2023/0698

Erection of extension to the south facing gable, replacement roof with a new concrete pantile covering and photovoltaic installations, replacement cladding to the east and west facing gable elevations and external works including resurfacing, new air source heat pumps/fenced compound area and new 1.8m high boundary fencing around site perimeter

New Lodge Community Park, Standhill Crescent, New Lodge, Barnsley, S71 1SH

Proposed Elevation B (South Facing)
Scale 1:50

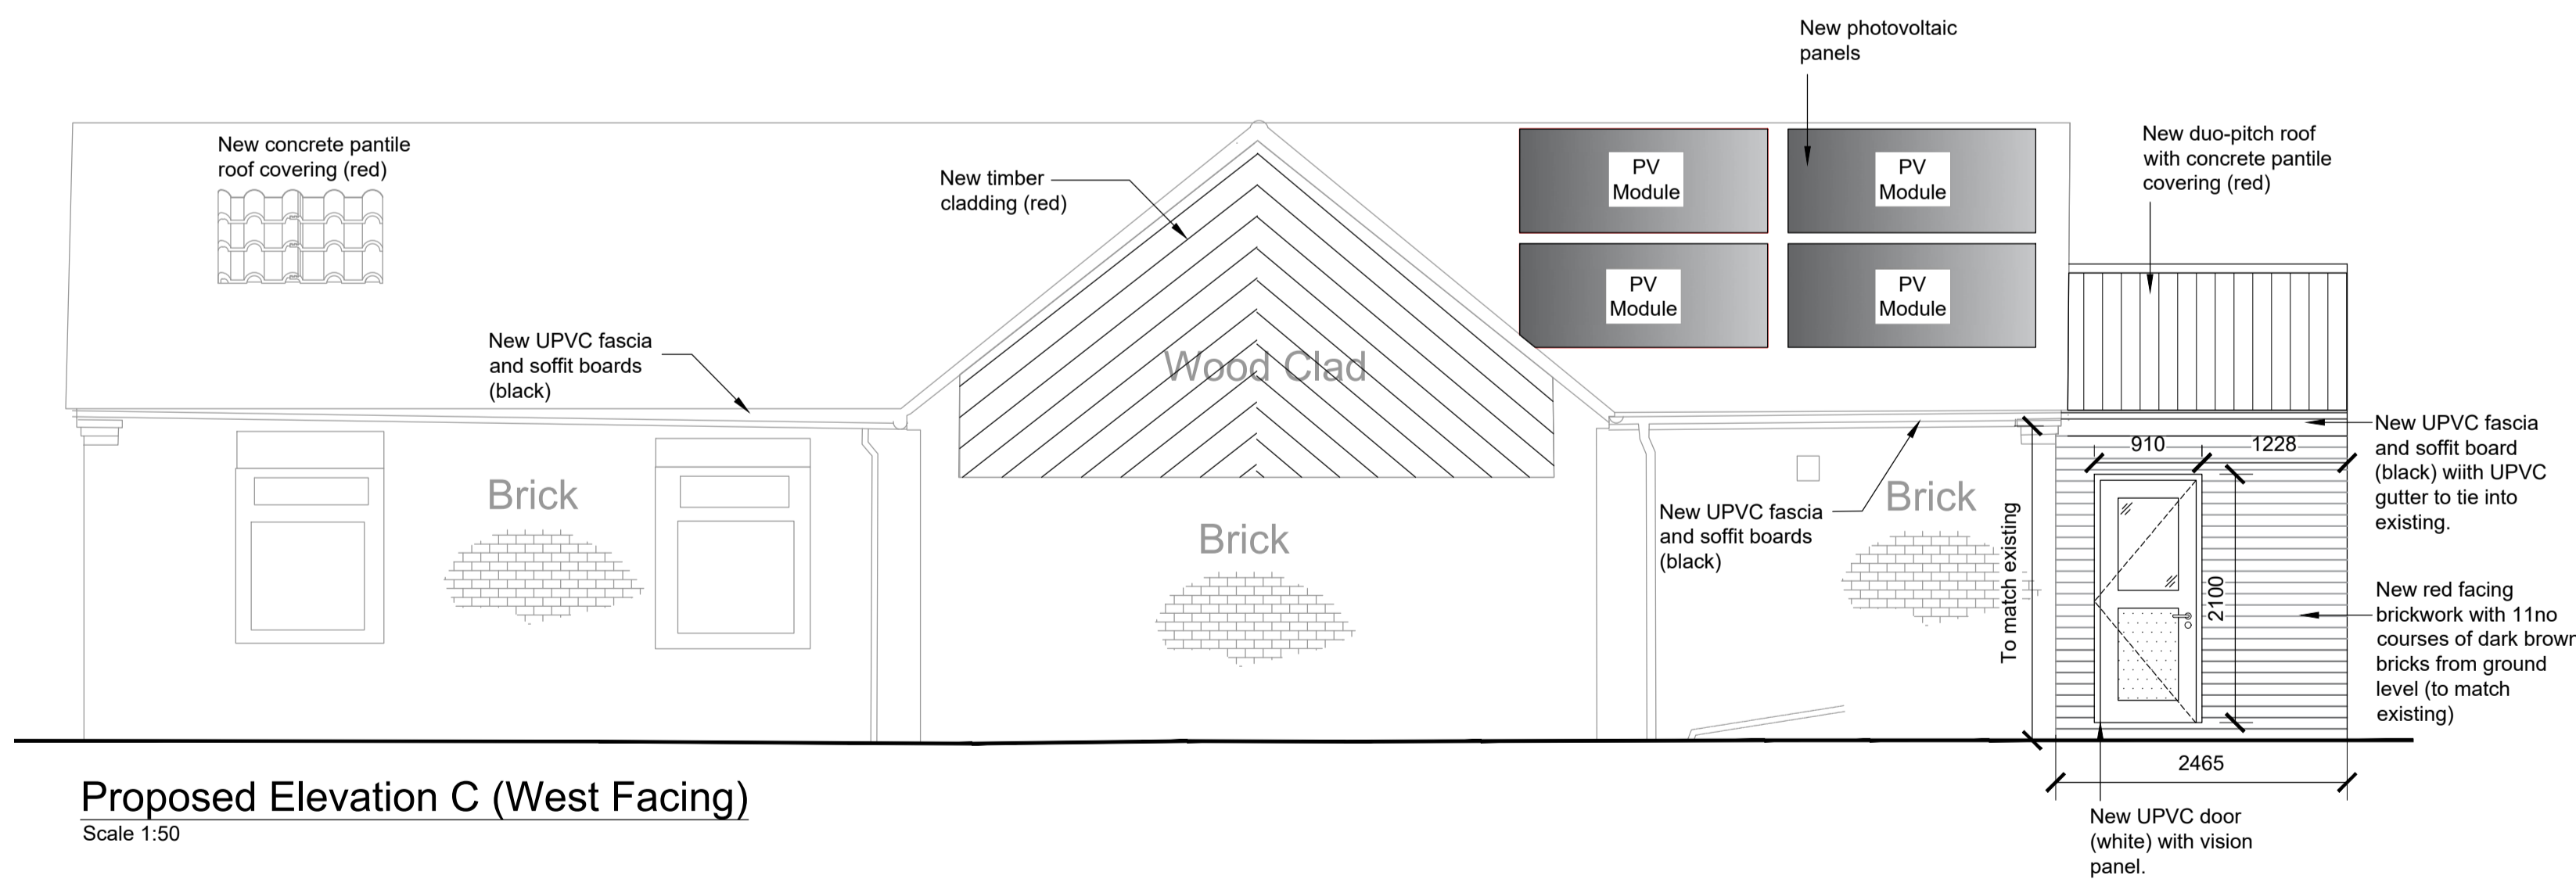
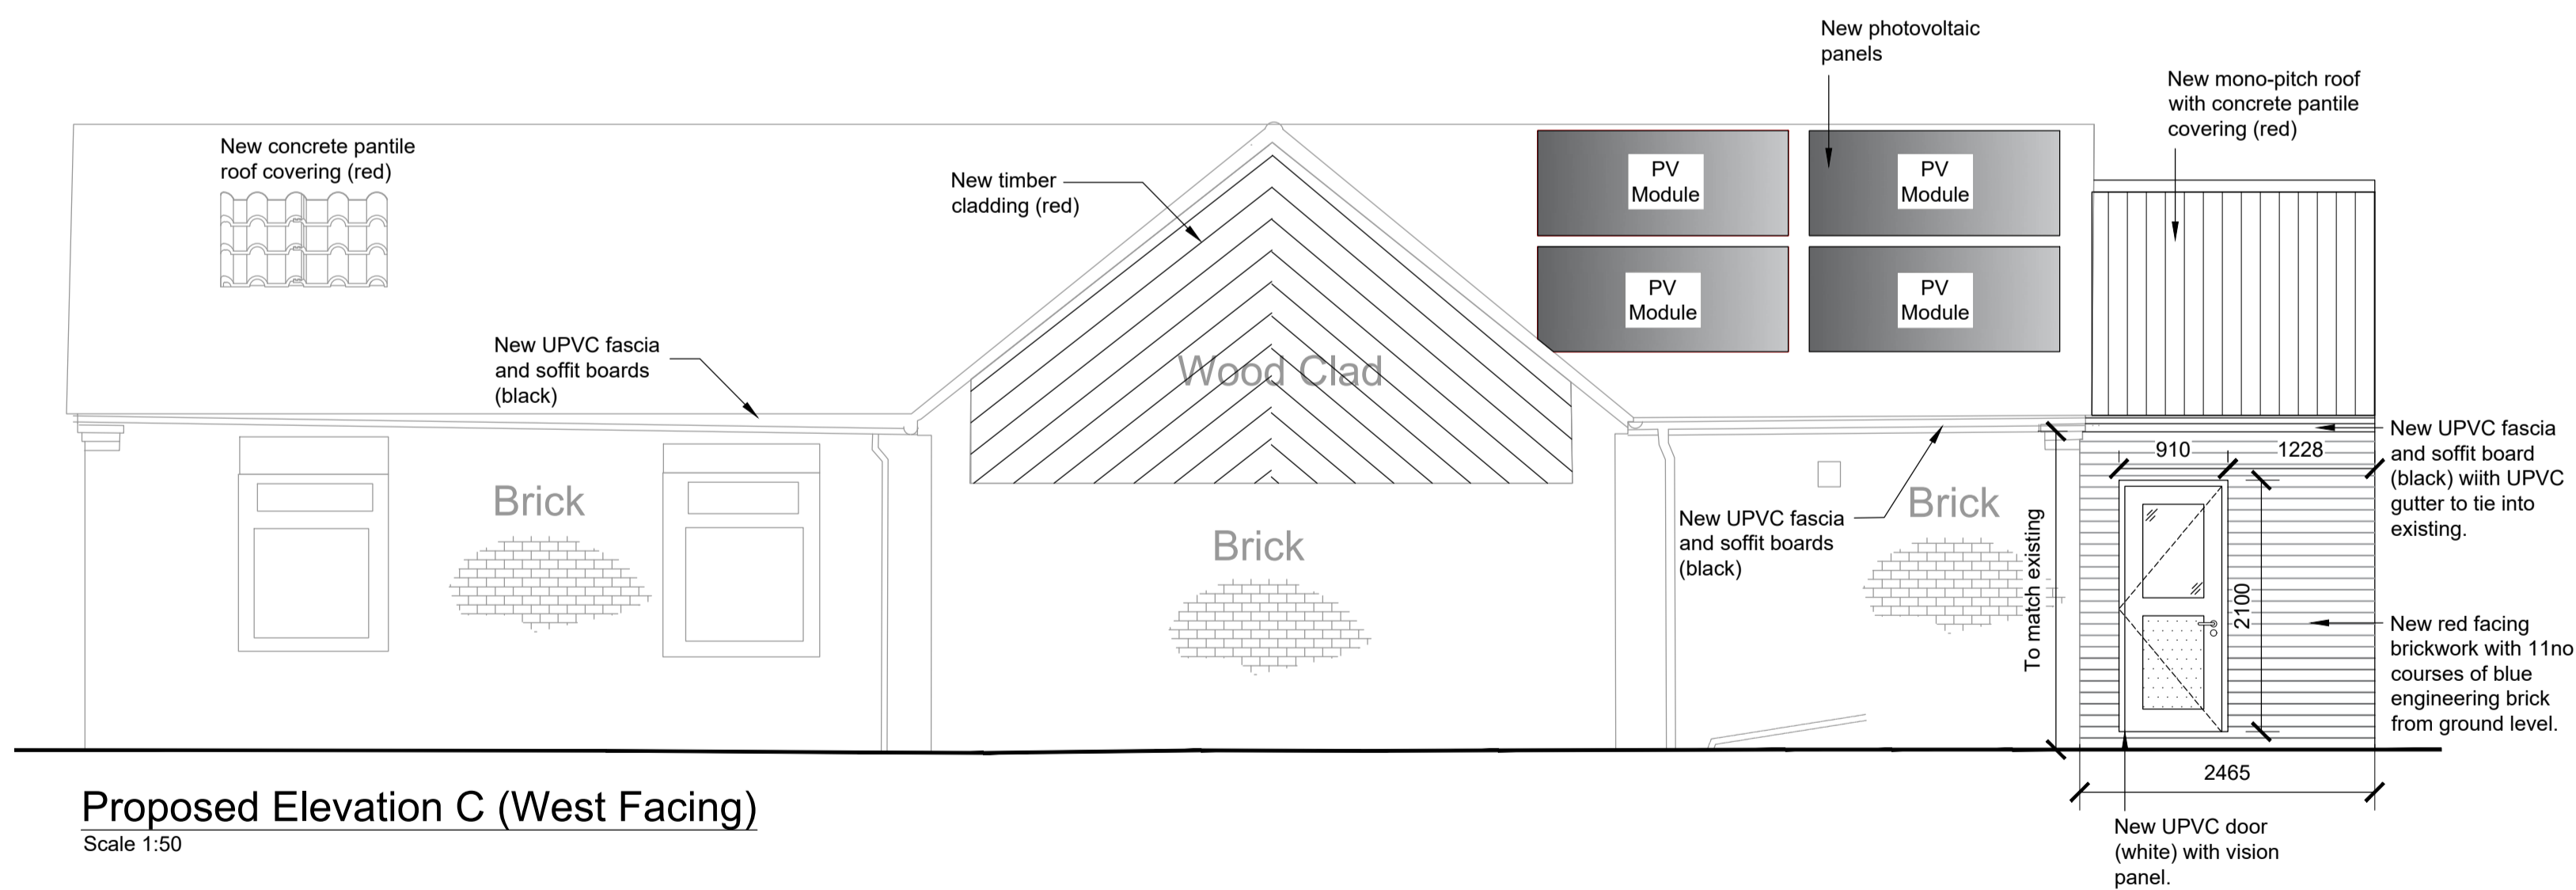
The proposed extension would be located on the southern side elevation of the existing building, the extension was initially designed with a mono-pitched roof with an expanse of brickwork facing New Lodge Crescent. This was considered unacceptable; the applicant made amendments upon request, incorporating a pitched roof, and reducing the overall height, which along with construction materials to match the original building, now harmonises with it, and is acceptable.
